# KITITAS COUNTY

### MEMORANDUM

**TO:** All Staff  
**FROM:** Public Works Plan Review Team  
**DATE:** February 24, 2025- UPDATE W/ SURVEY COMMENTS  
**SUBJECT:** BL-25-00003 Graaff

GRAAFF PROPERTY

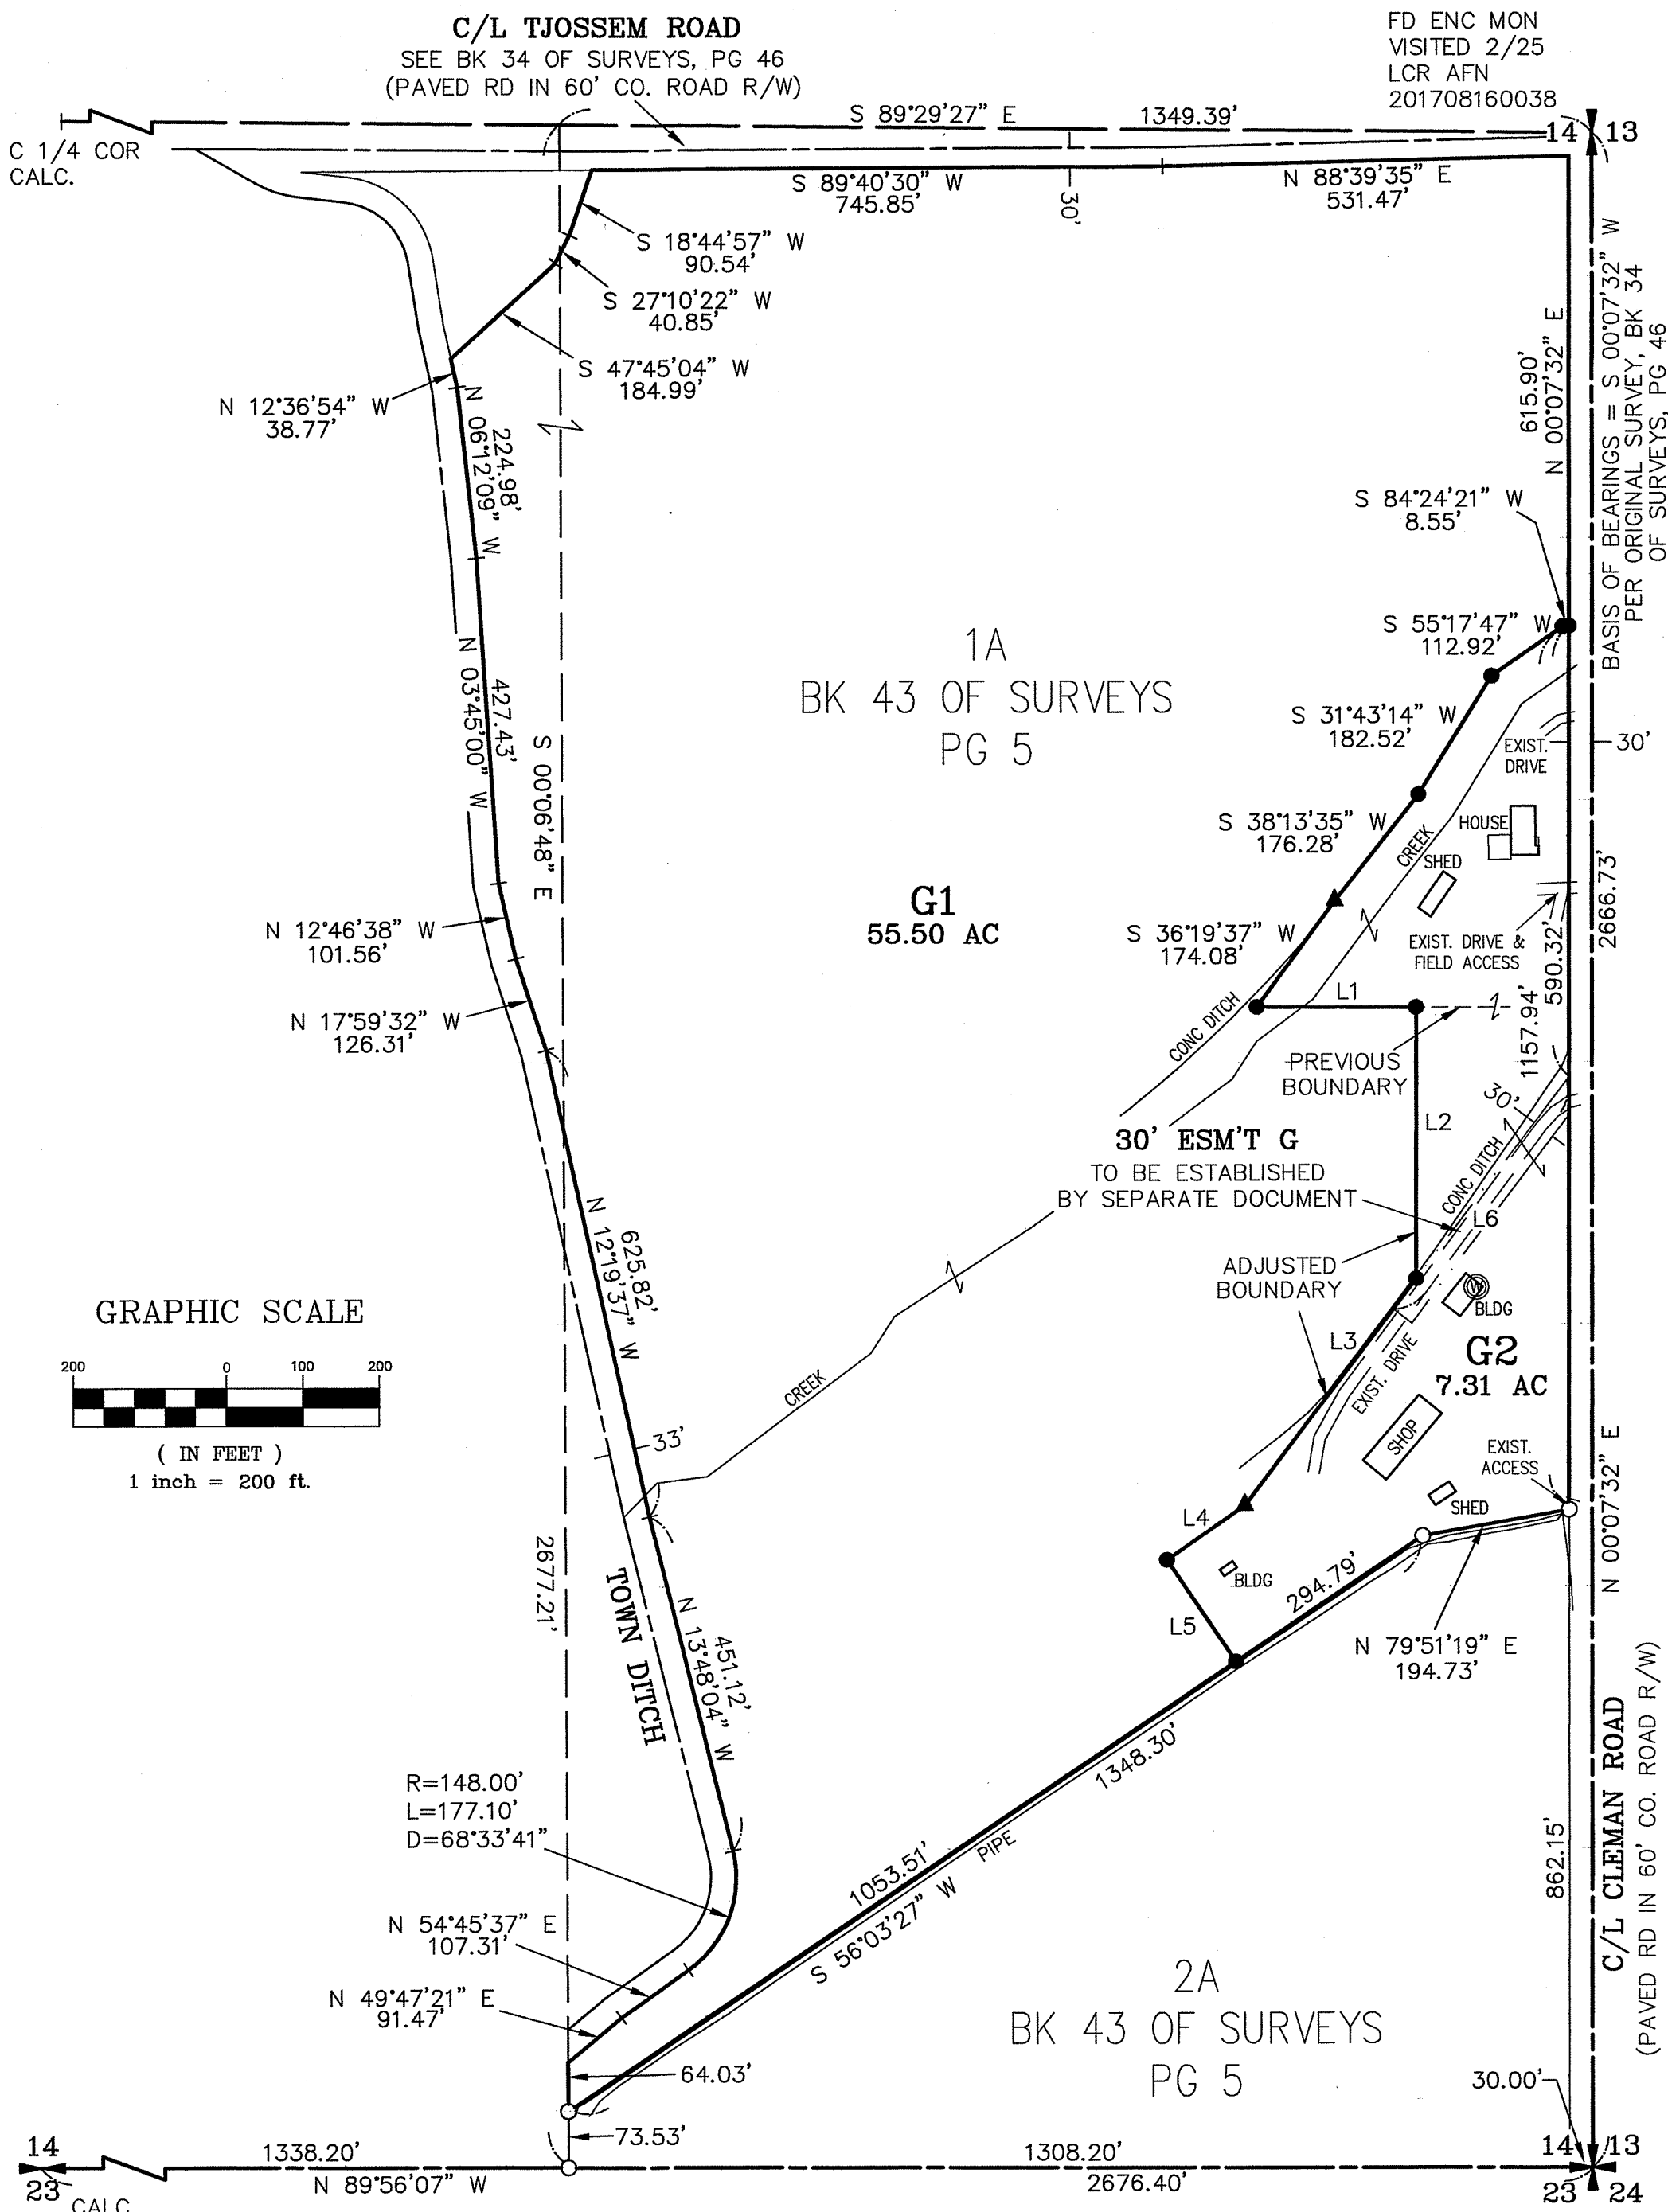
<b>ENGINEERING</b>	<p>Except as exempted in KCC 14.05.060, no grading or filling upon a site involving more than one hundred (100) cubic yards shall be performed without a grading permit from the County Engineer or Public Works designee (KCC 14.05.050). An application for grading in excess of five hundred (500) cubic yards shall be accompanied by an engineered grading plan (KCC 14.05.080). (CP)</p>
<b>SURVEY</b>	<p>As the application does not contain a survey map, survey comments are herein reserved until final. (JR)          SURVEY COMMENTS UPDATED 2/24/2025          Lot closure summary for Lot "G1" is missing Line L3 from lot closure summary. Could be scan error? (DF 022425)</p>
